# CITY OF ALBUQUERQUE

July 6, 2021

**RE: Wintergreen Apartments  
10800 Golf Course Rd NW  
Grading & Drainage Plan and Drainage Report  
Engineer's Stamp Date: 06/08/21  
Hydrology File: A12D008D**

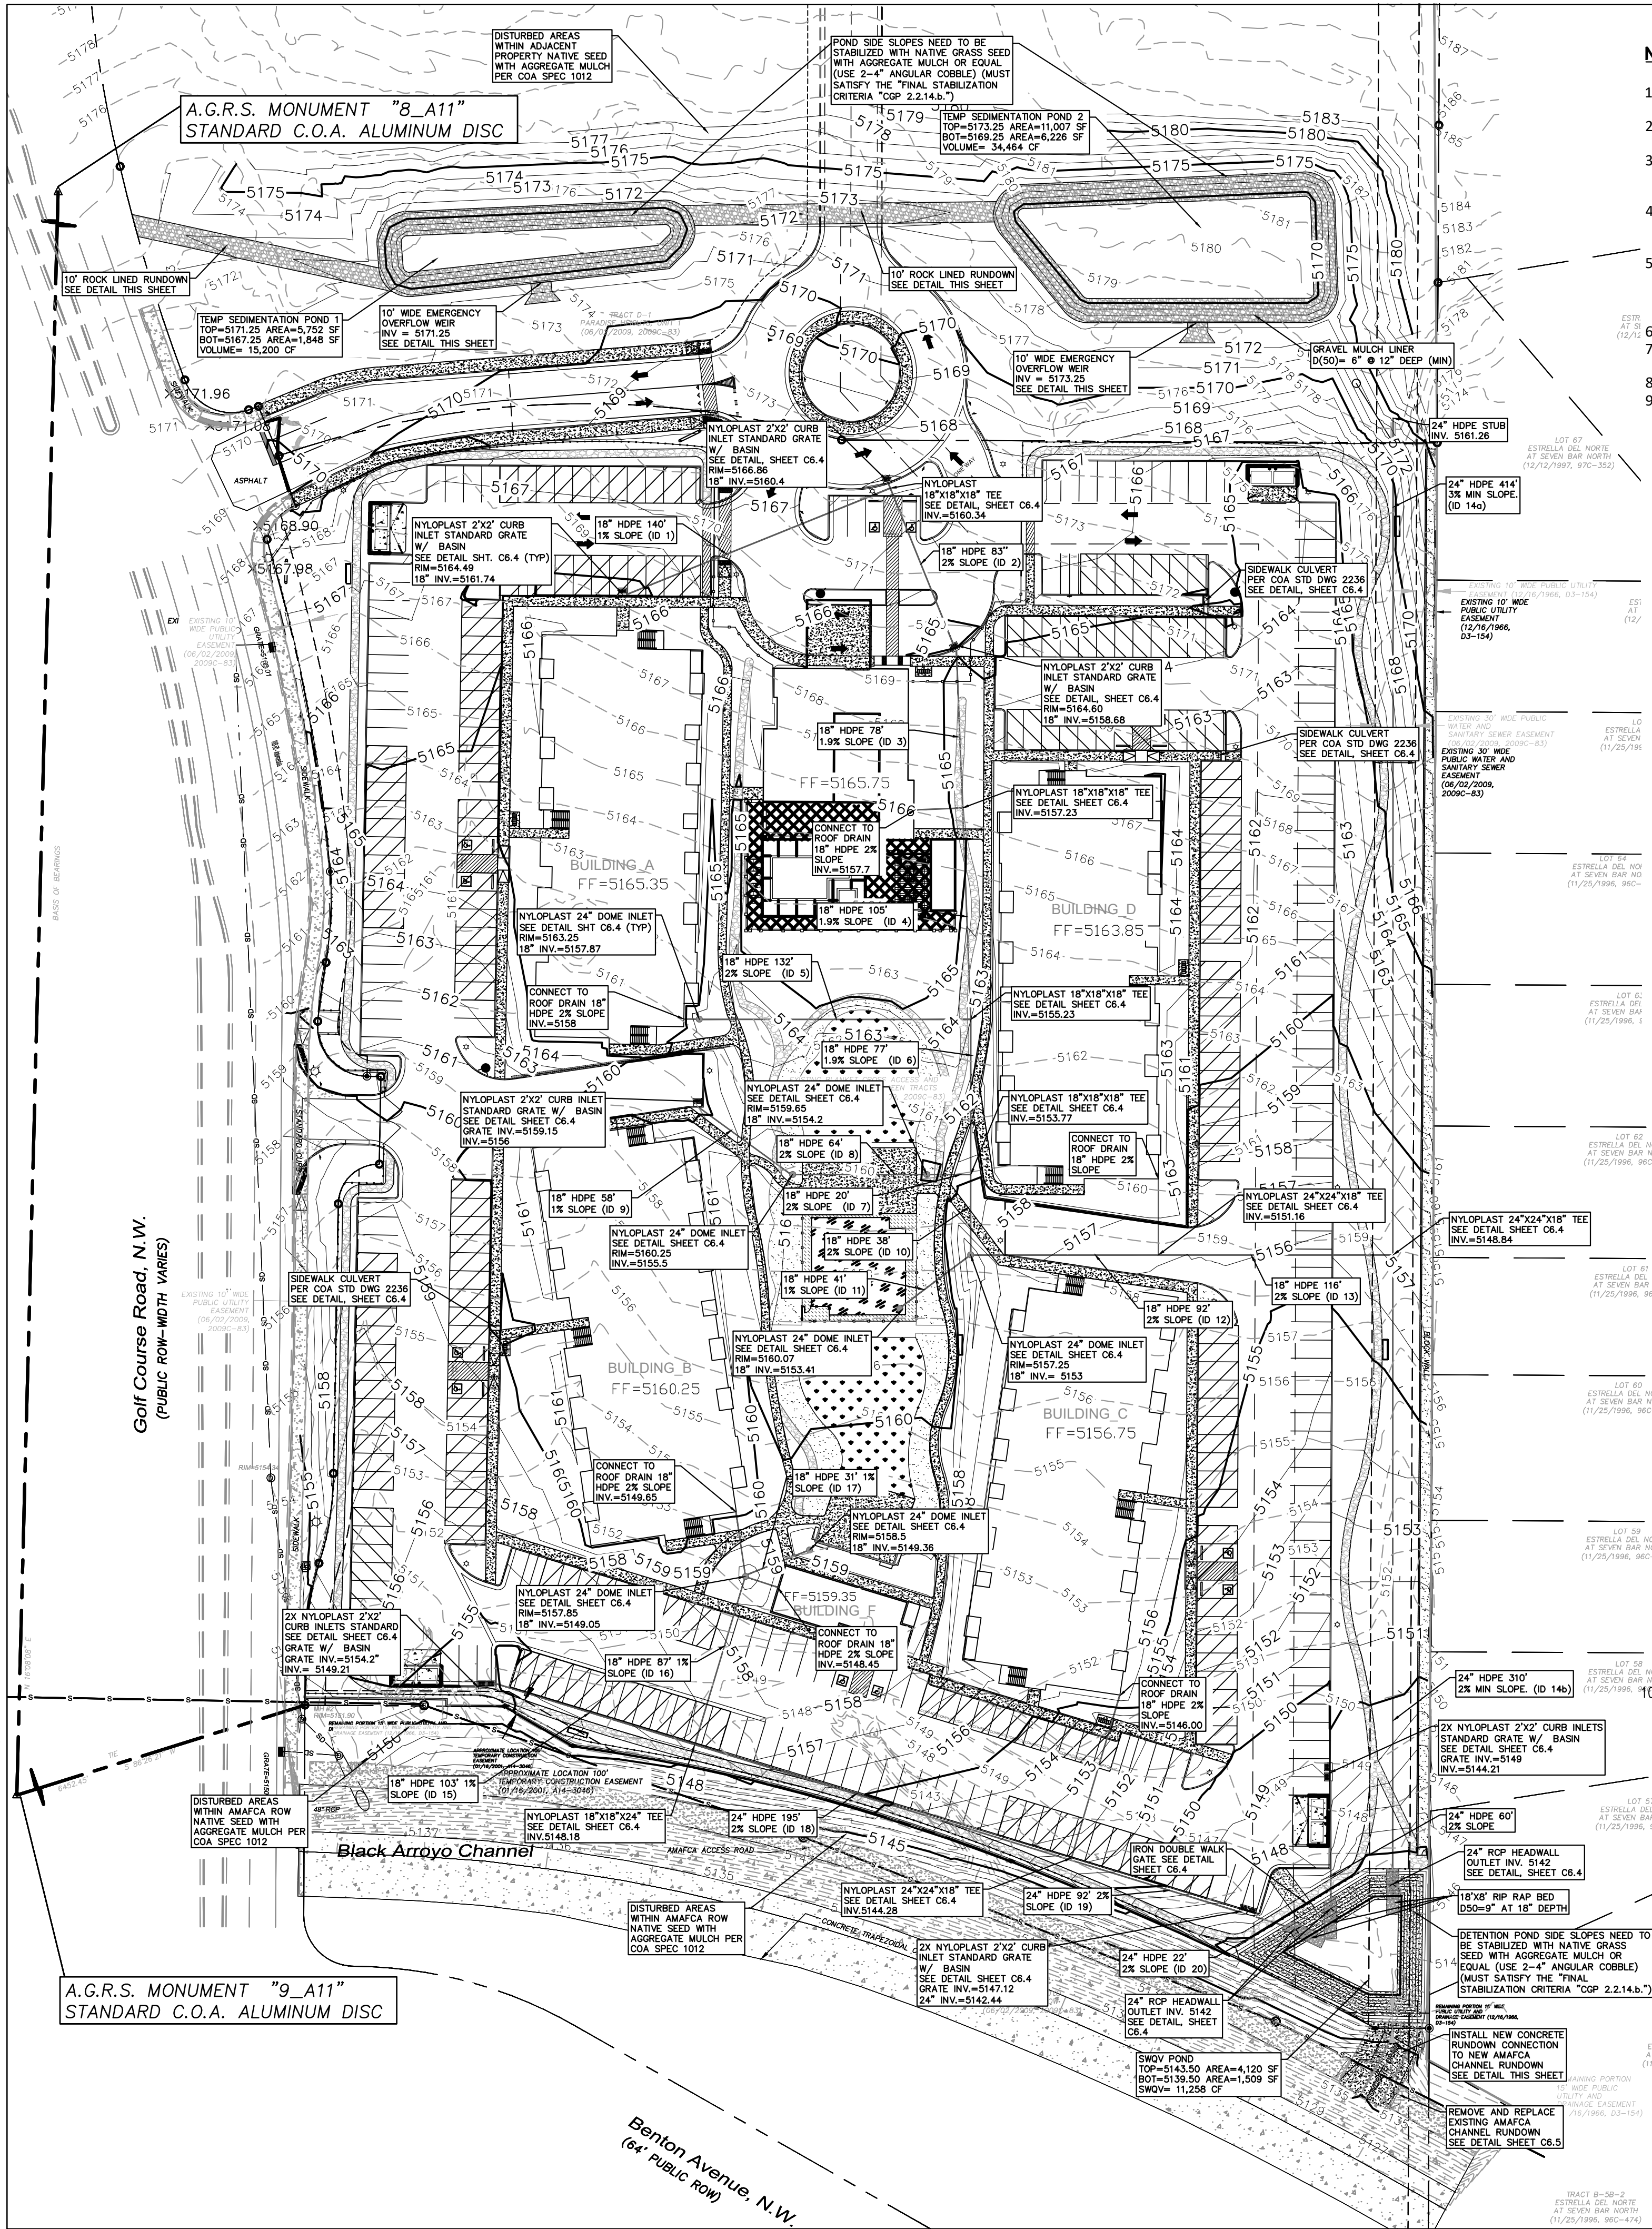
3. Sheet C3-C5. Please either add a note, "all spot elevations next to curbs is flowline elevation" or add "FL" behind those spot elevations that are next to the curbs.
